Your Ref: OWQC20068
Our Ref: R/183/18/HH
Please ask for:
Ms S Allen

Front ground floor extension, ridge extension to form gable w all over front extension, 2 new bedrooms & bathroom in roof space with dormer extension to side, 2 velux windows provided in existing roof slopes.
8 Acre Close Rustington

Thank you for your internet comments made on 1st October 2018 which has been recorded as **'an objection'** with the comments as follows:

existing east elevation.

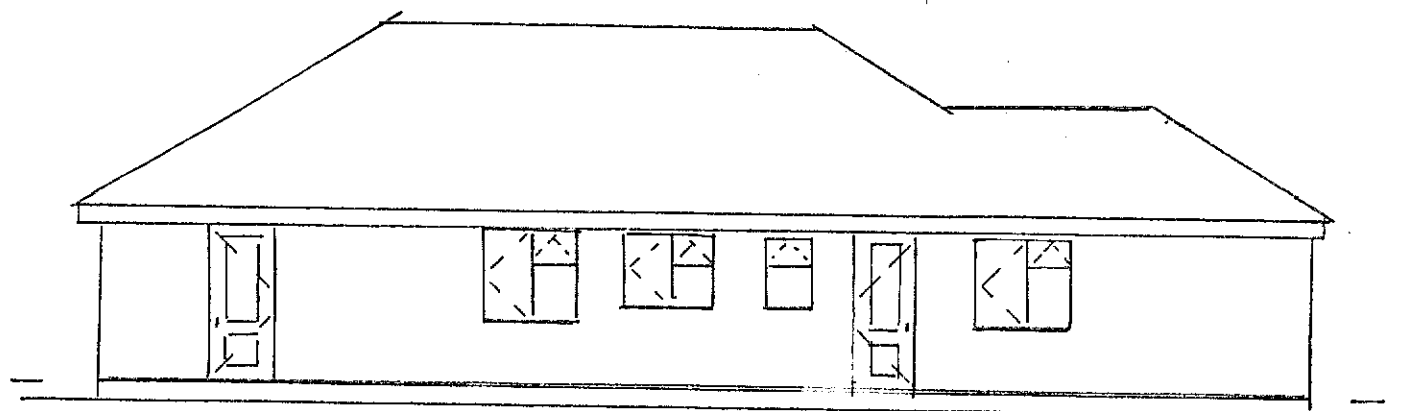
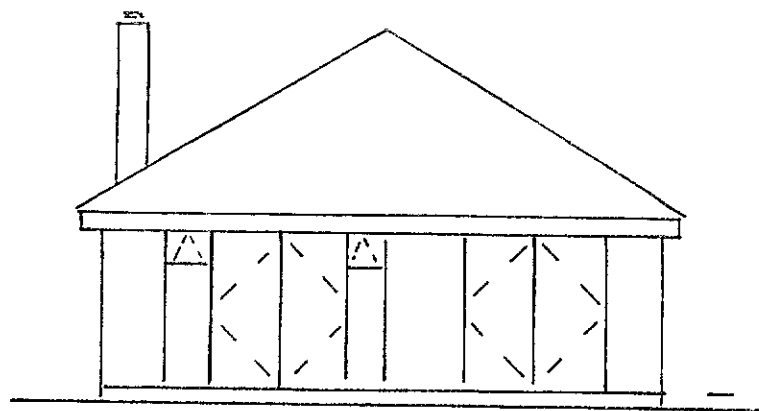
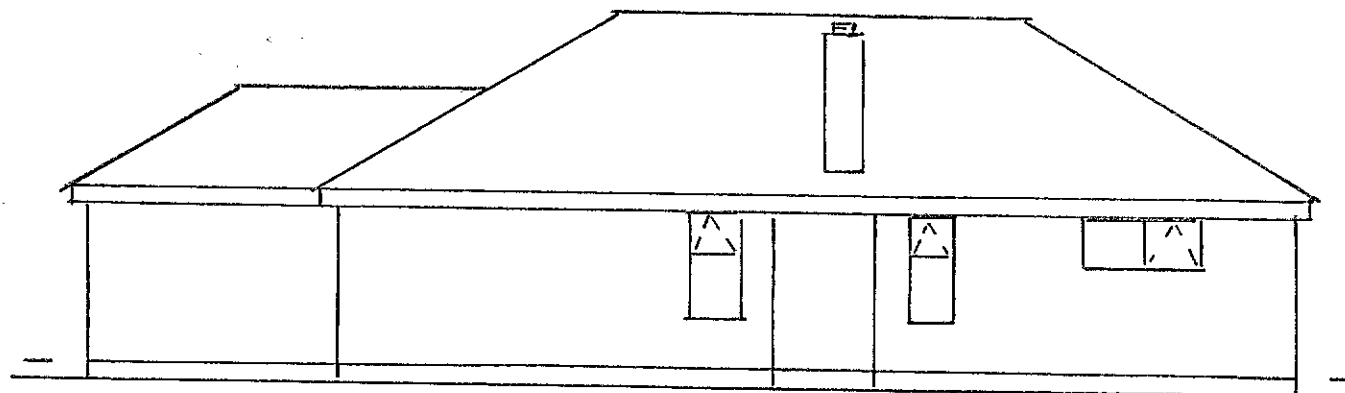
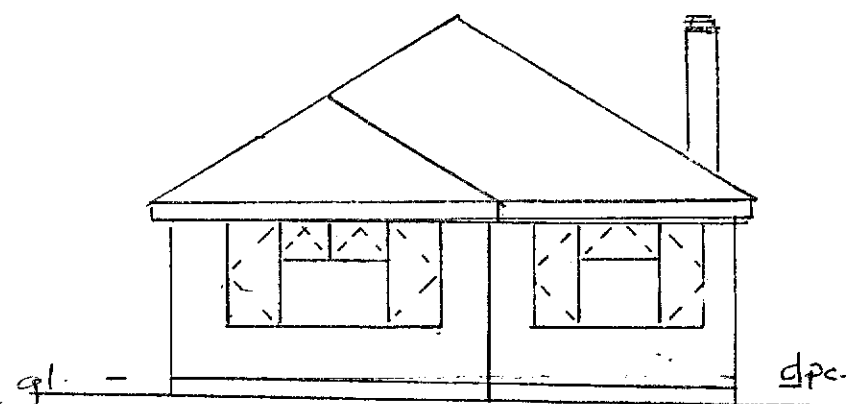
(i) The proposal, in respect of the east facing Velux style windows, would result in a severe loss of privacy for the occupier of No. 7 Acre Close, by reason of overlooking to an unacceptable degree. This would most certainly adversely affect the peaceful enjoyment and amenities of the occupier of the aforementioned property

(ii) The proposal would be out of keeping with the street scene and surrounding area overall.
